# Clarification Questions from first submission

Shed floor layout

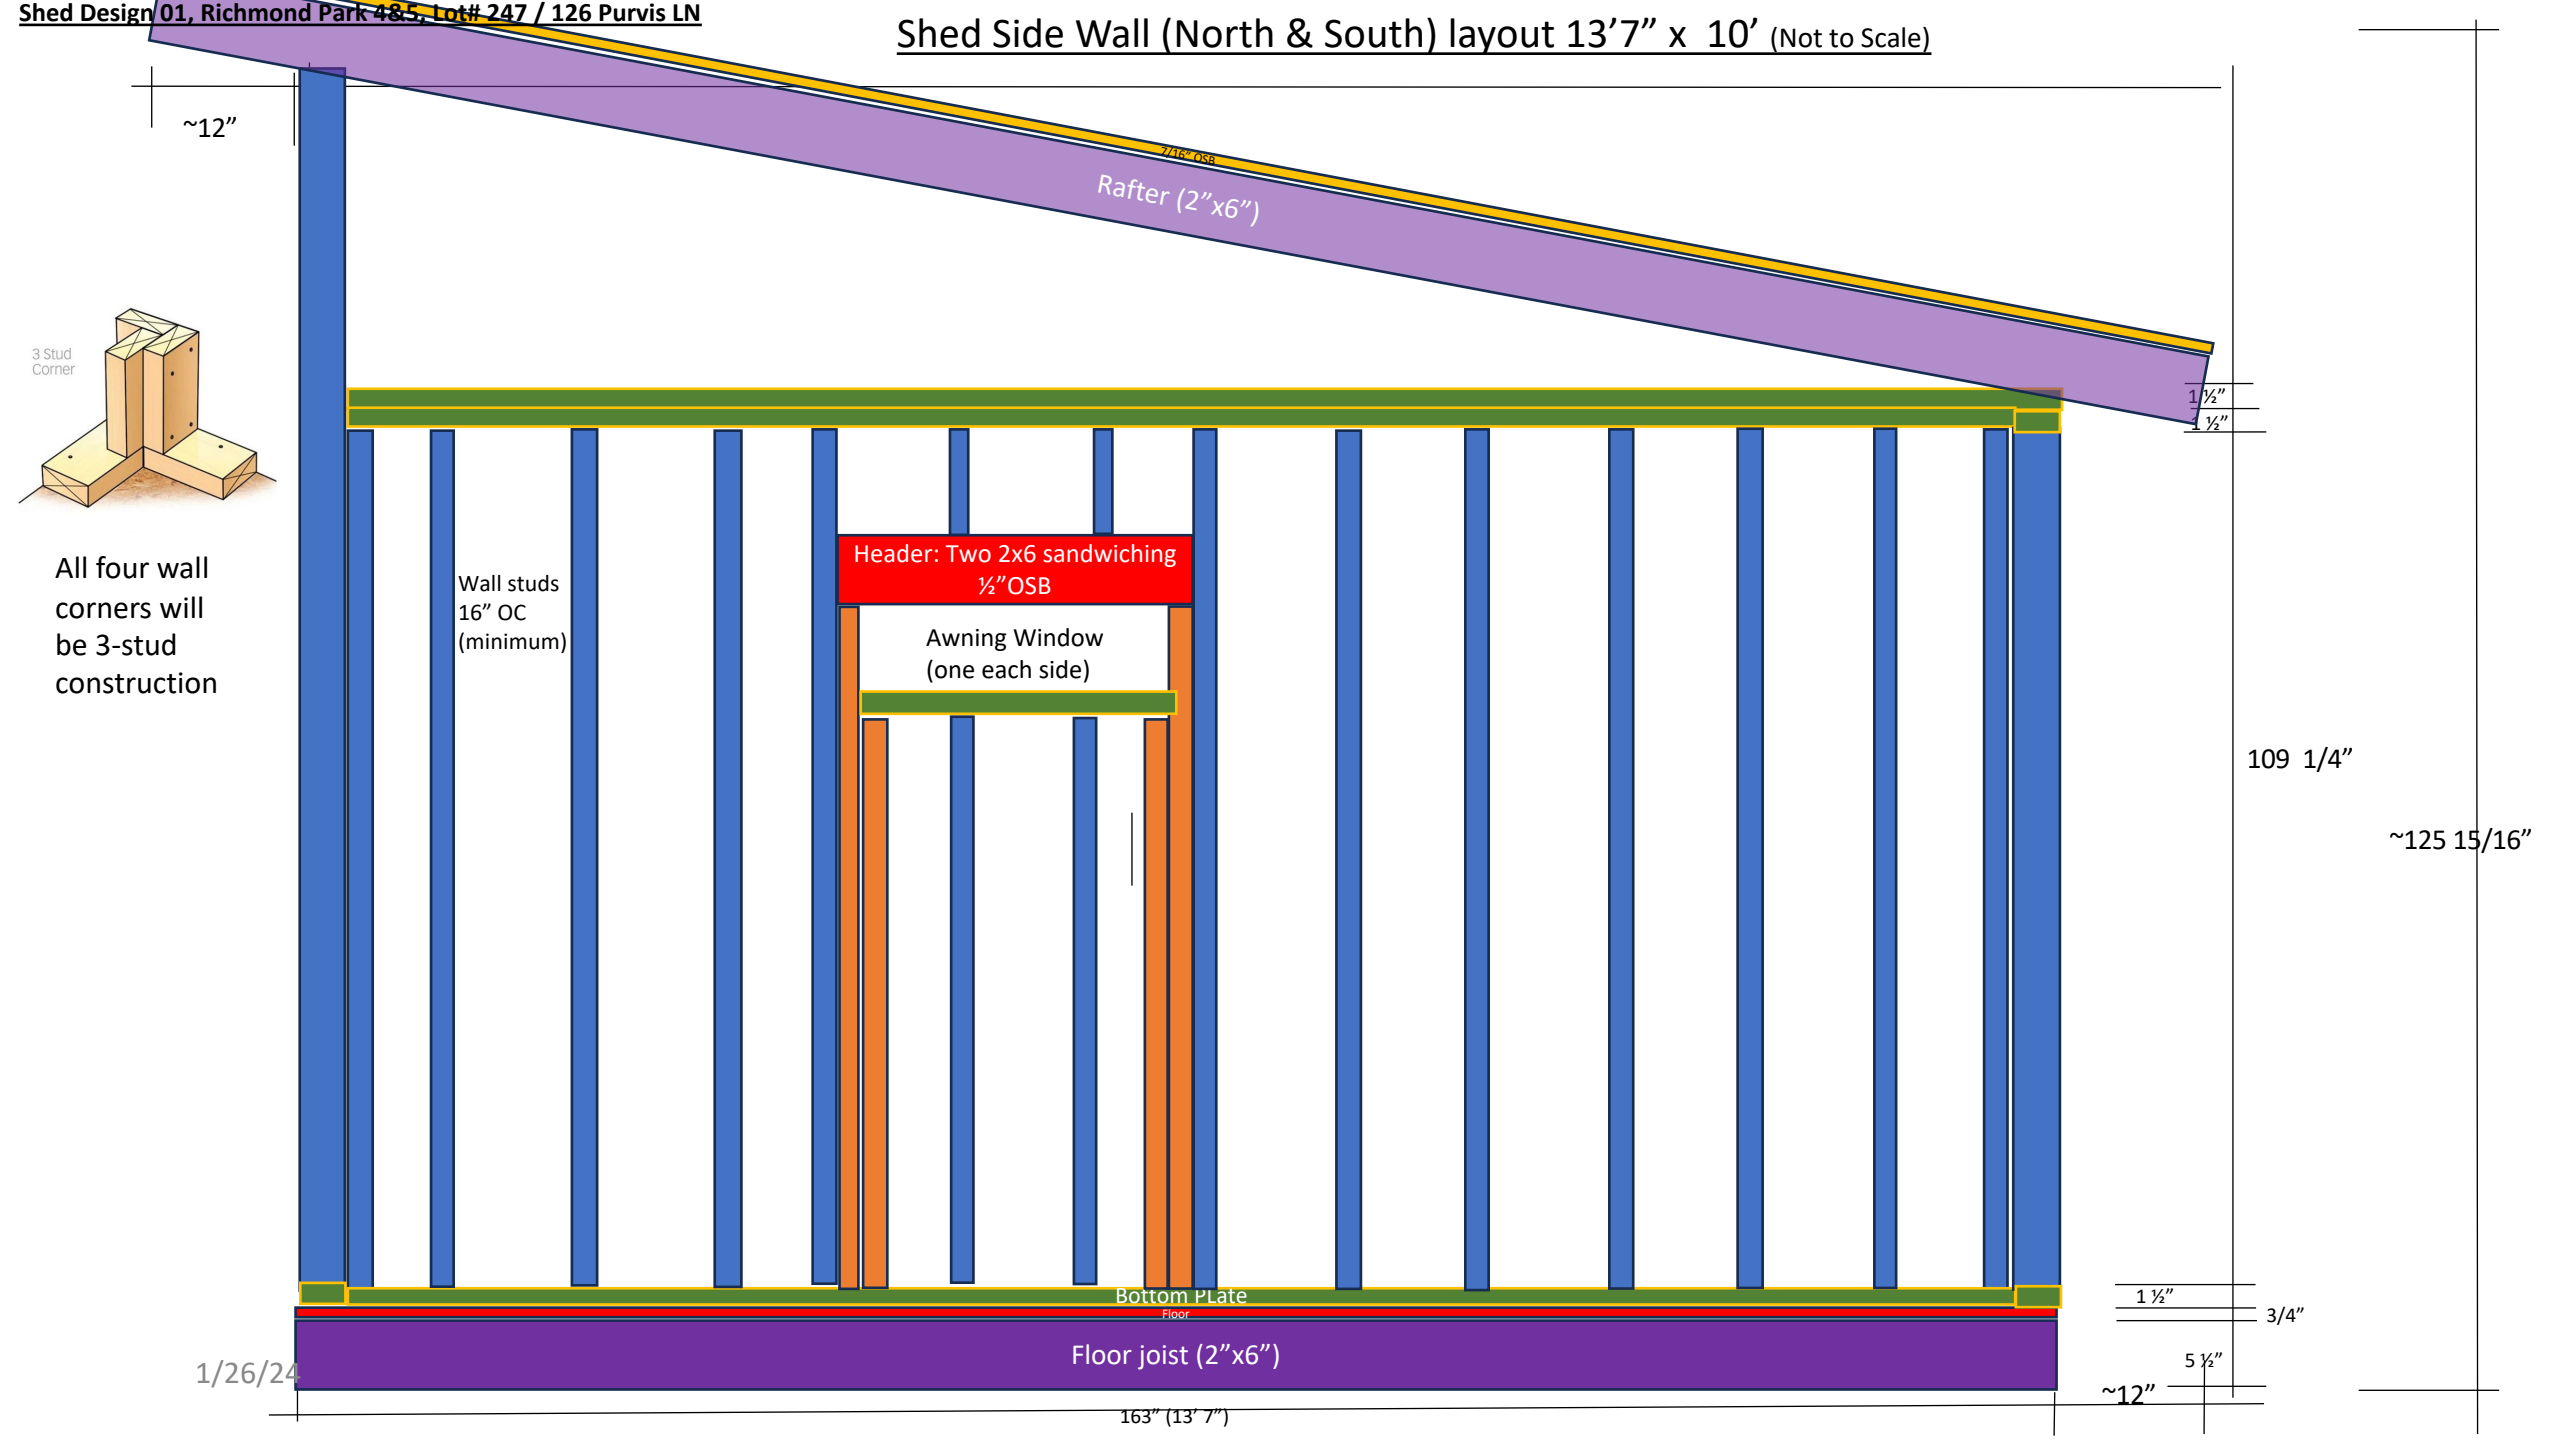
1. Floor framing size, spacing, and how floor system will be supported on gravel base?

**Answer:** Framing will be 2"x6" ground contact lumber, 16" on center. The gravel base is 3/4" washed stone bordered by ground contact 4"x6" beams bolted together and secured in place with 1/2" rebar 24-36" long.

Shed Side Wall (North & South) layout 13'7" x 10' (Not to Scale)

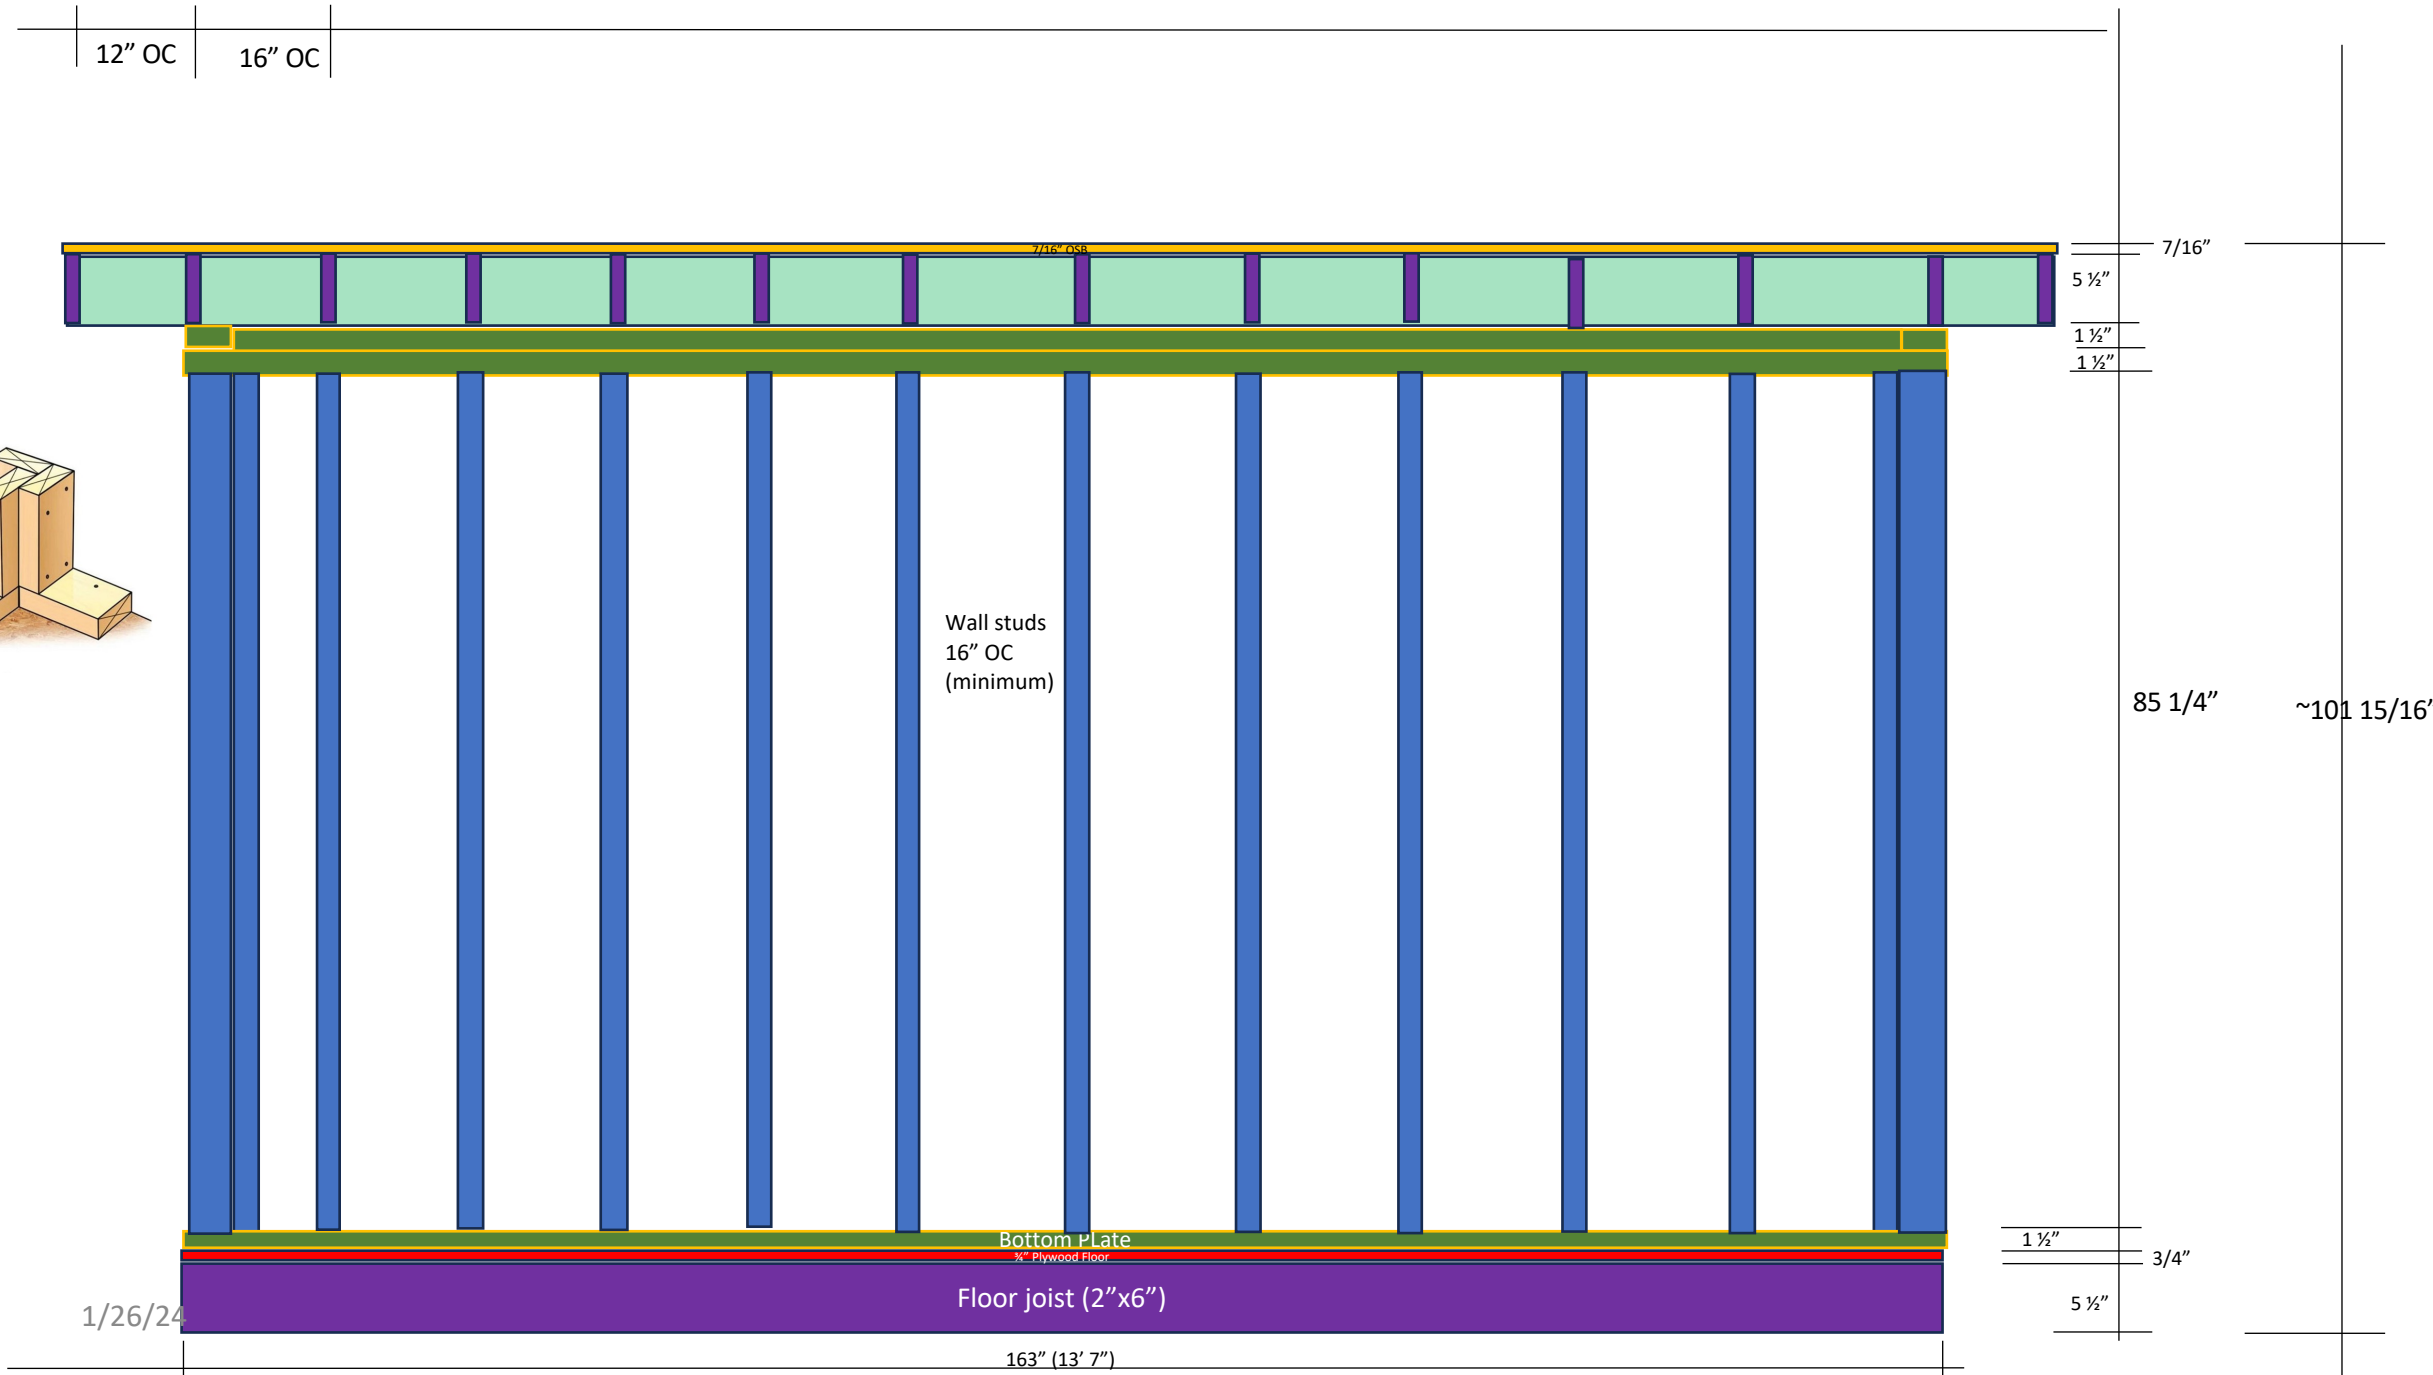
2. Wall framing details including header sizes over all openings?

**Answer:** Walls will be 2"x4"s at 16" on center. Bottom plates will be ground contact 2"x4". Walls will be double top plated. Headers over all windows and doors will be two pieces of 2"x6" "sandwiching 1/2" osb. Wall corners will be 3-stud construction.

Shed Roof layout 16' x 14' (Not to Scale)

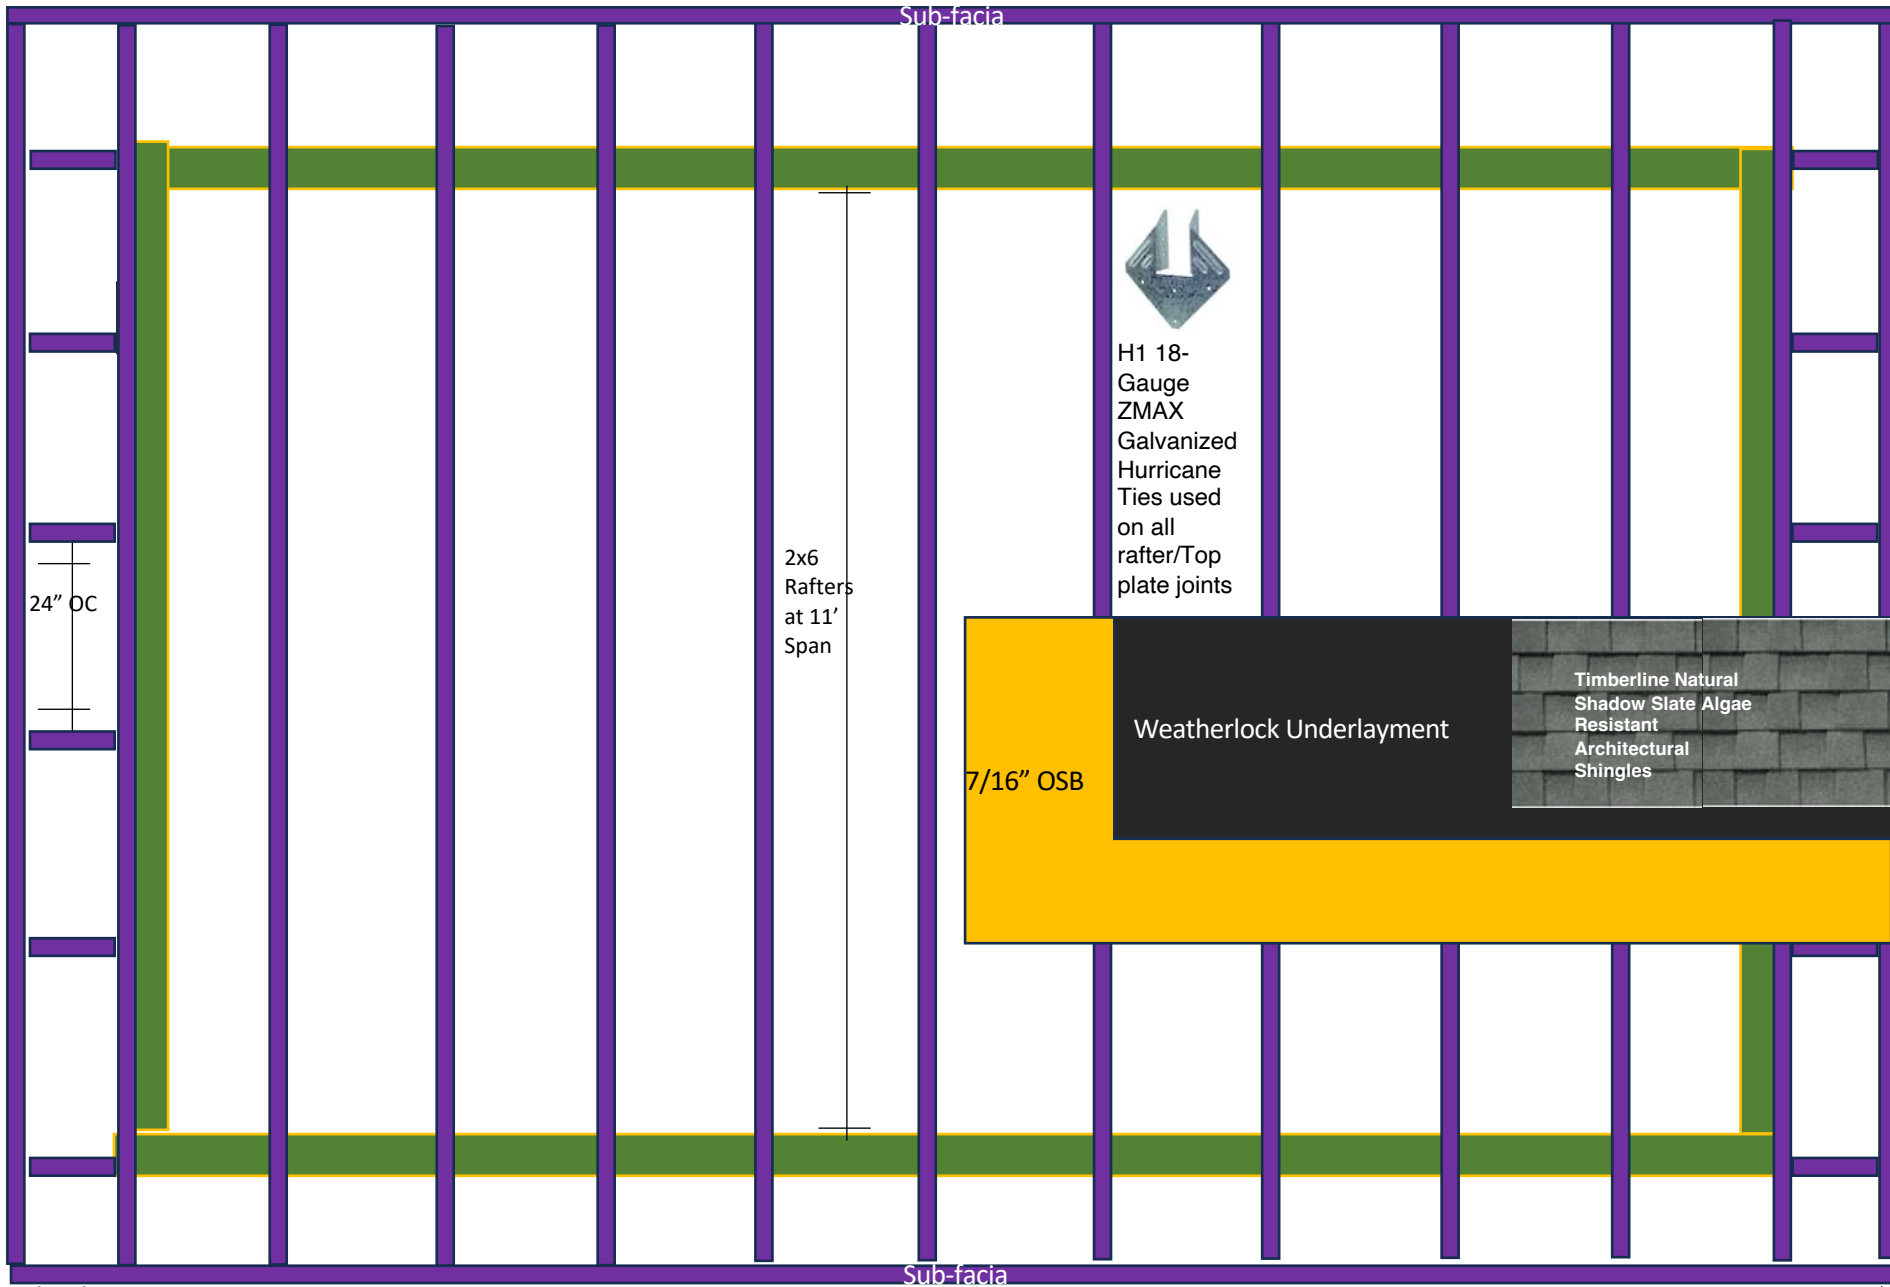
3. Roof design- size and spacing of roof and ceilings members?

4. Roof pitch and roof covering?

**Answer:** Roof will be a lean to at 2.5/12 pitch, using 2"x6" rafters at 16" on center. Sheathing will be 7/16" OSB covered with ice shield underlay and 25year shingles to match the house. Rafters will be reinforced with hurricane galvanized ties.

**Answer:** please see #3.
